# CITY OF ALBUQUERQUE

October 30, 2024

After a thorough review of your minor amendment application for the Eastdale Shopping Center, located at 9450 Candelaria Road NE, we have the following comments that must be addressed prior to approval. If any portion of the proposed amendment can stand on its own, we may proceed with approving just those portions and may delay other site plan changes to the future, if desired.

Project
EASTDALE SHOPPING CENTER
 ALBUQUERQUE, NEW MEXICO

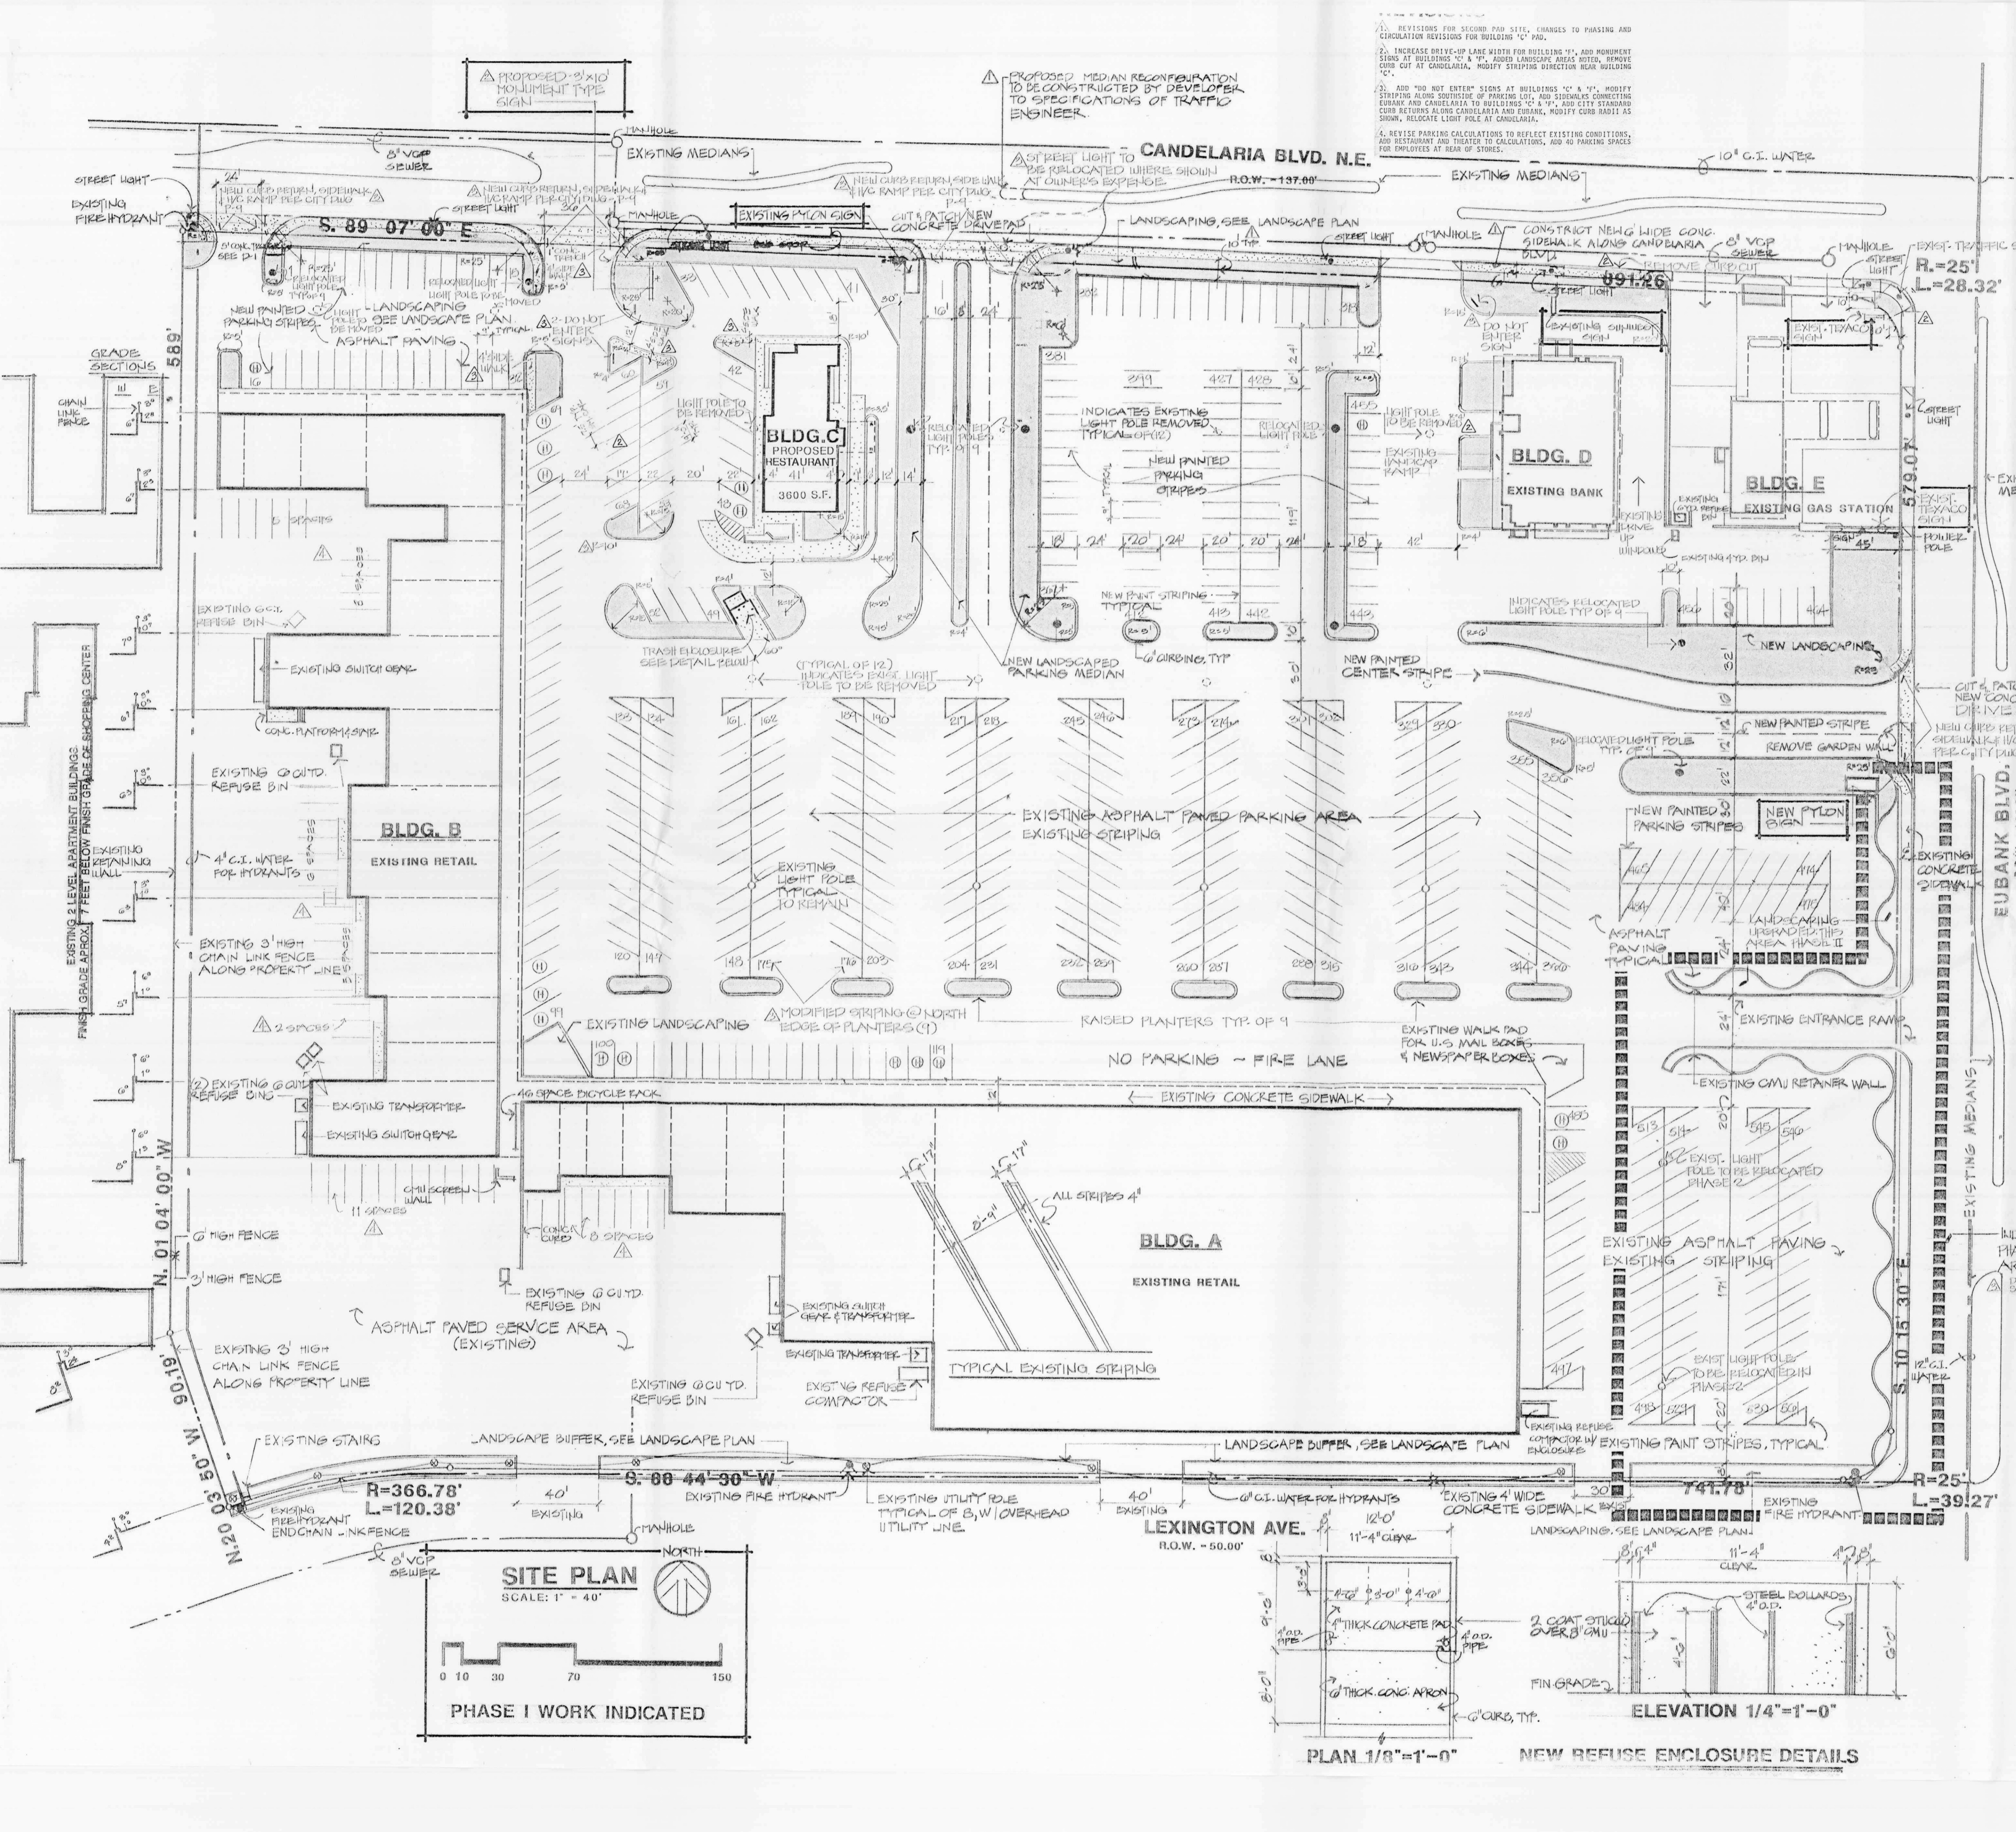
4. Are shopping cart corrals excluded from the parking space calculations pursuant to IDO §14-16-5-5(F)(1)(a)3?
5. The original site and plan began with 858 parking spaces and appears to have proposed to drop to 566 spaces provided once build-out was complete.

6. Minor amendments are generally limited to a 10% change to “Any other numerical standard” [IDO Table 6-4-4]. 920 parking spaces is within this range from the original 858 existing spaces from the 1986 plan. It is a 14% increase in parking from the number listed on the 2015 plan, and significantly more from what was the originally proposed final condition on the 1986 plan.

11. A minimum of 15 percent of the net lot area of each development shall contain landscaping. Please provide this calculation on the landscape plan. The two restaurant pad sites meet this newer requirement, but for the site as a whole it is unclear as the original 1986 plan provided between 16-20% of the paved parking area as landscape, and not all of that landscape was installed.

18. At least 15 percent of the parking lot area of lots containing 50 or more spaces, shall be landscaped. This was met by the 1986 proposal with up to 58,659 square feet of landscaping proposed at the time, although not installed. Please provide updated calculations.
